# FARNHAM WITH STRATFORD ST ANDREW PARISH COUNCIL

20 February 2020

Re: EDF New Nuclear Build's Sizewell C nuclear power station proposal

**DRAWING TITLE:**  
 TREE ROOST INSPECTION RESULTS -  
 TWO VILLAGE BYPASS  
 SHEET 3 OF 3

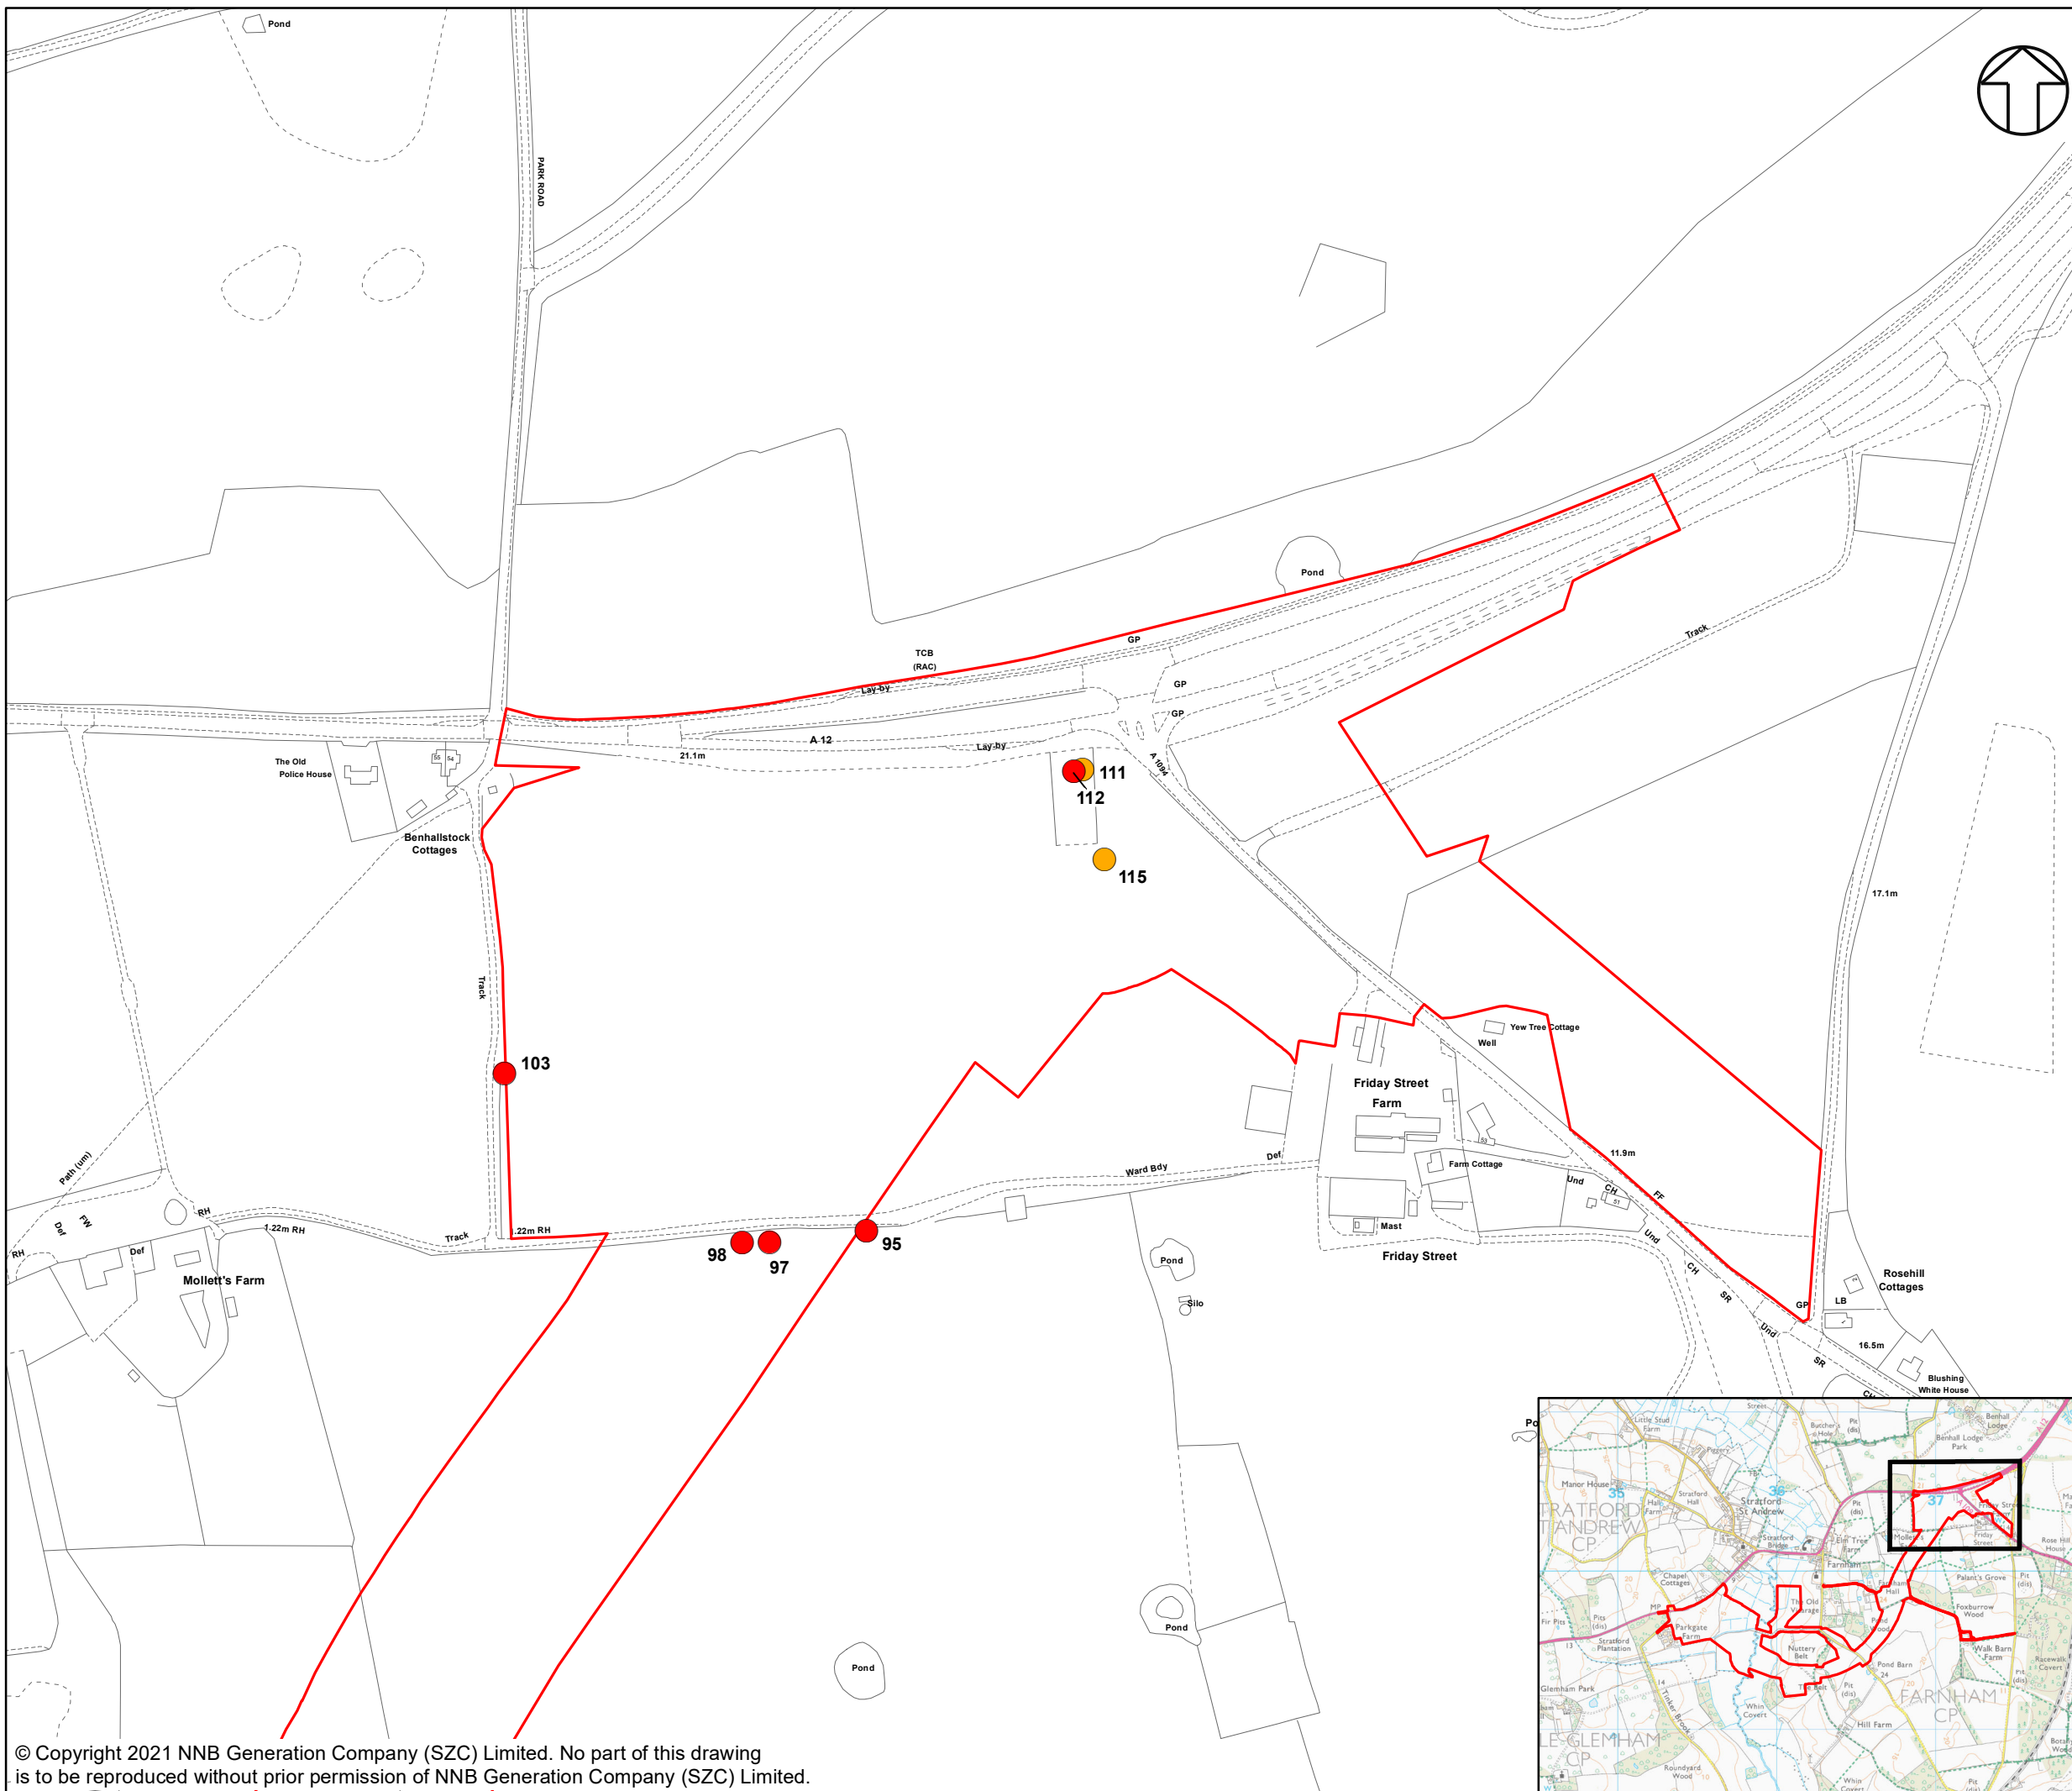
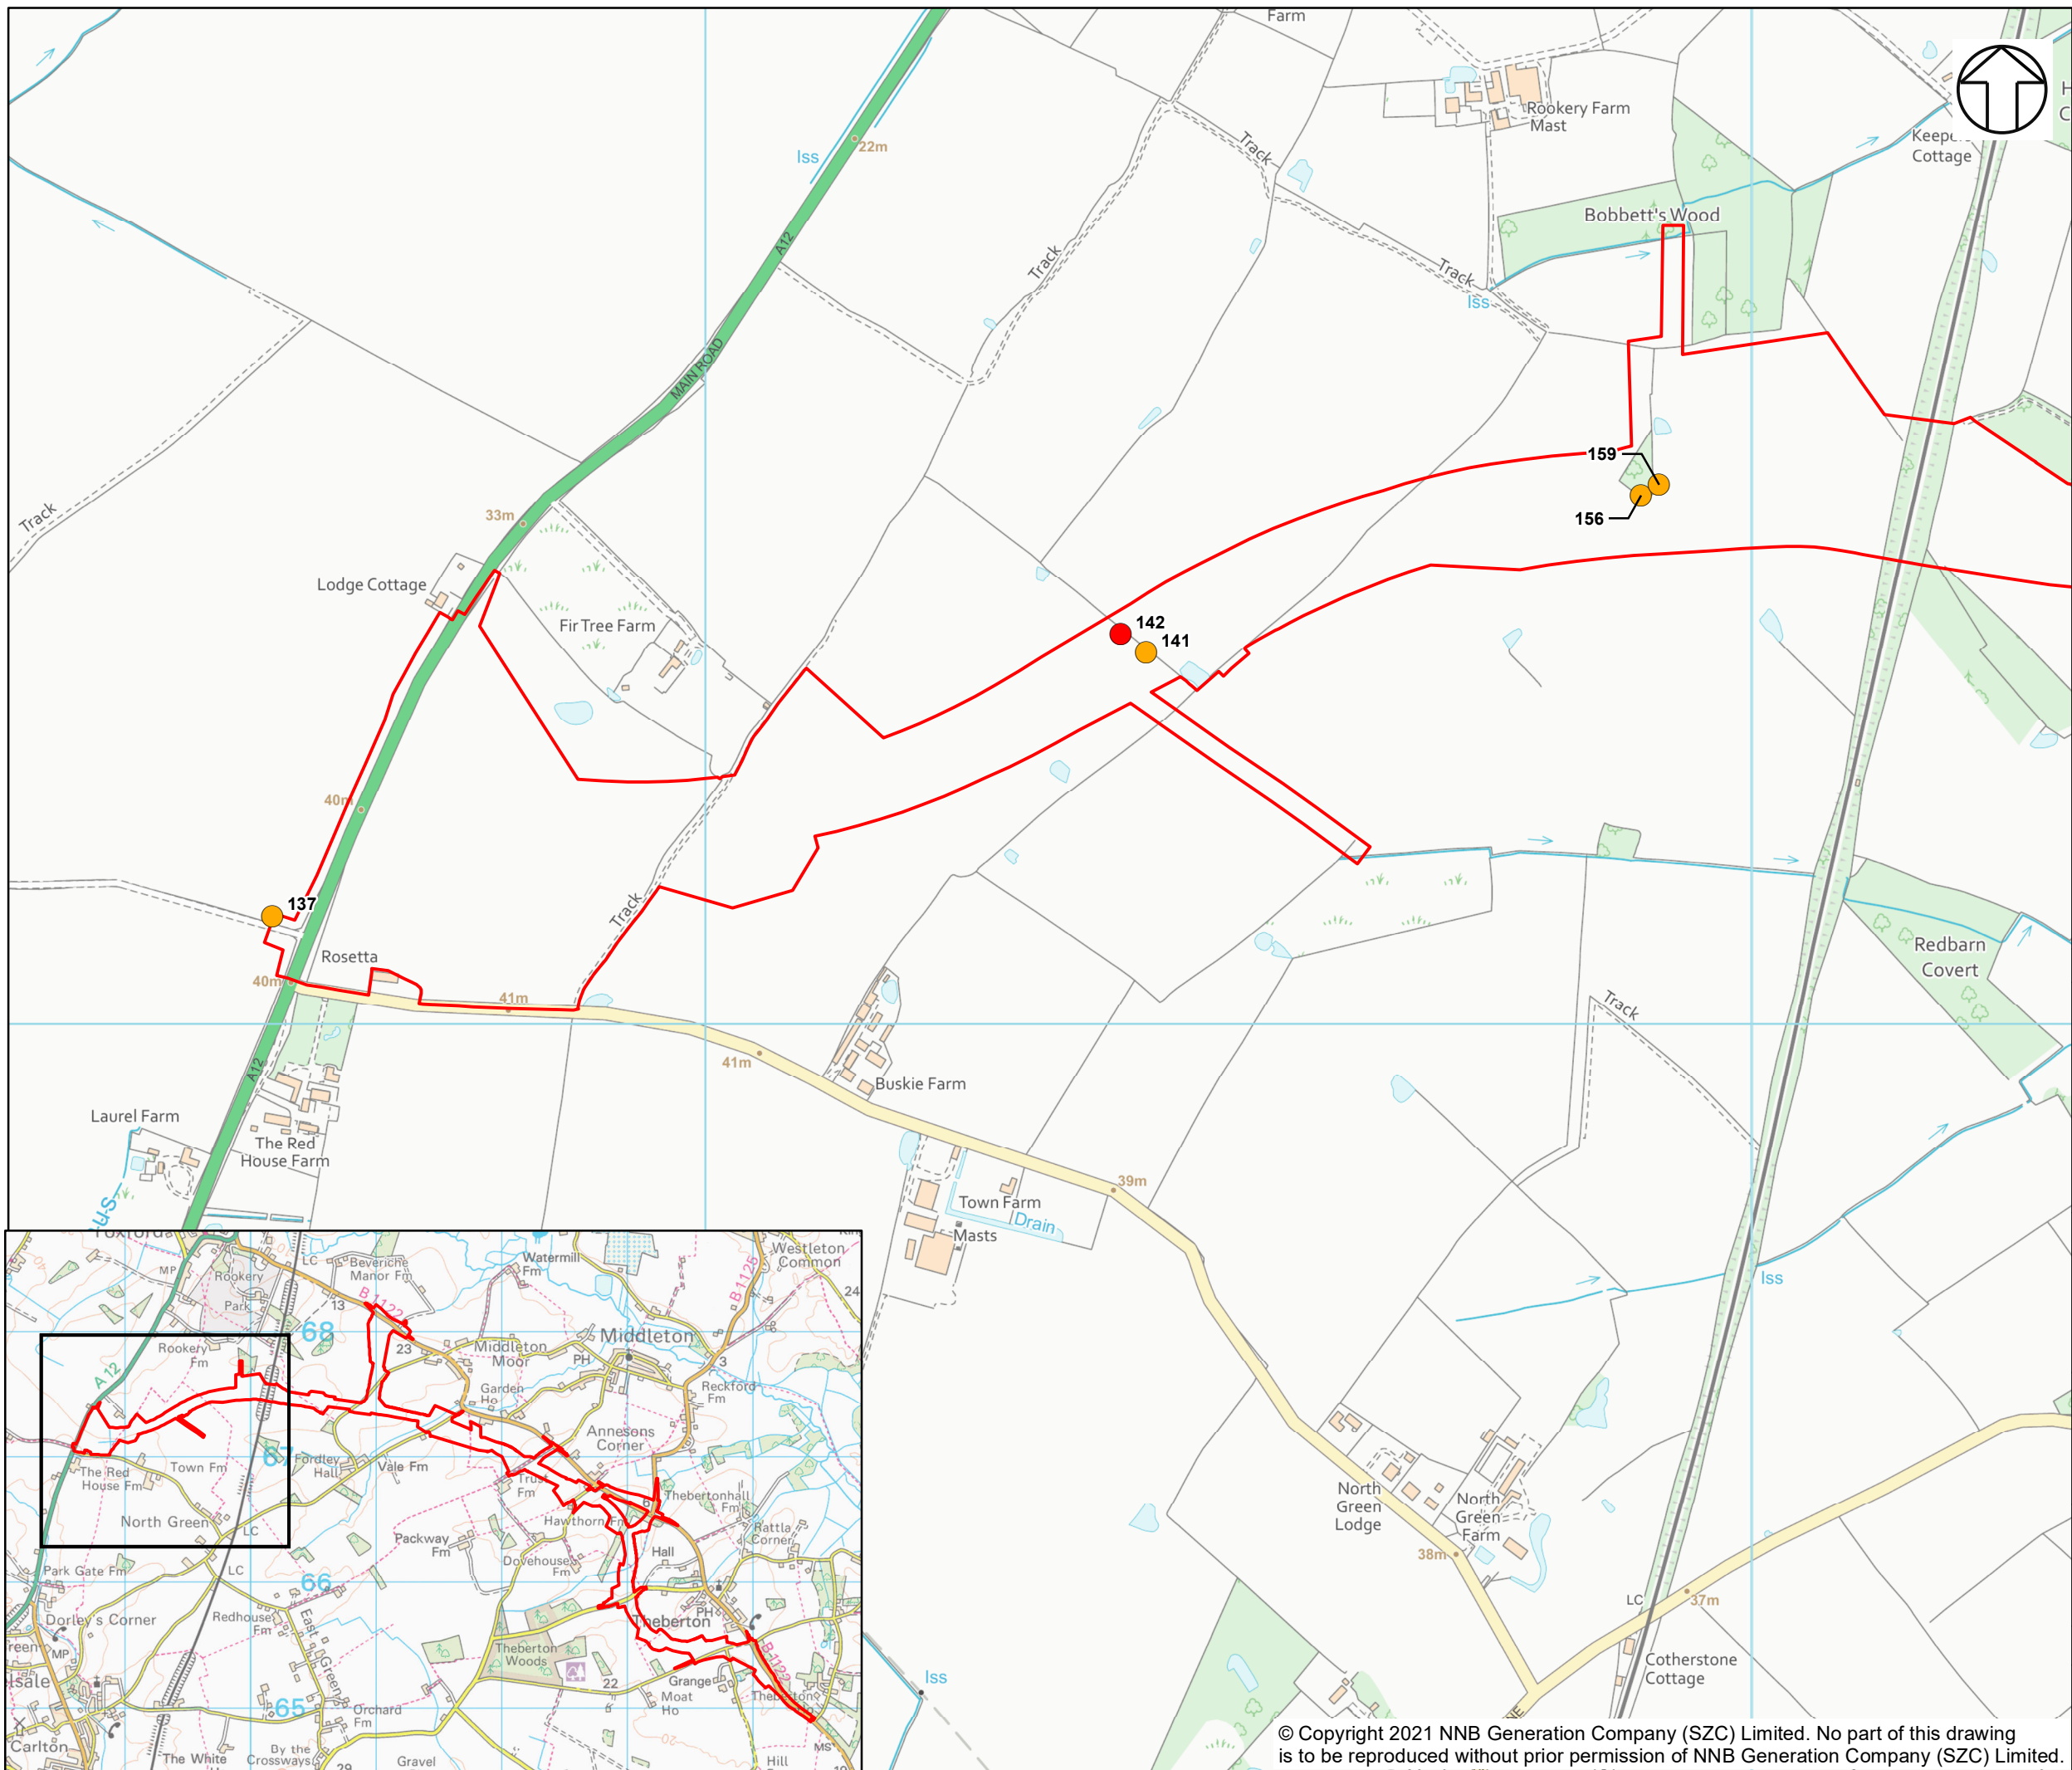
*In our response to the Stage 2 consultation we recommended that the two-village bypass should go to the east of Foxburrow Wood, rather than the west. This is still the parish council's position.*

*EDF has proposed a two-village bypass route to the west of Foxburrow Wood which passes through this narrow gap and then cuts through the tree-lined track between Farnham Hall Farmhouse and “Farnham Hall”.*

*EDF makes a misleading statement in 7.2.25 of their Preliminary Environmental Information when stating “the closest properties in Farnham are over 500m from the proposed route.” The proposed route would in fact place all twelve of the above-mentioned “Farnham Hall” properties and two others within 200m of the centreline of the carriageways, before any account is taken of the road's final width or the footprint of each property and their gardens. Real-life separations may be as small as 50m.*

*We consider that EDF's suggested route to the west of Foxburrow Wood will:*

- i. Adversely impact the setting of Grade II listed heritage assets,*
- ii. Cause the above residents to be exposed to high levels of noise, dust, emissions and light pollution – both during road construction and operation,*
- iii. Destroy their current rural landscape setting and views,*
- iv. Impact locals and visitors using the PRoW,*
- v. Sever the sole access to one of these properties.*
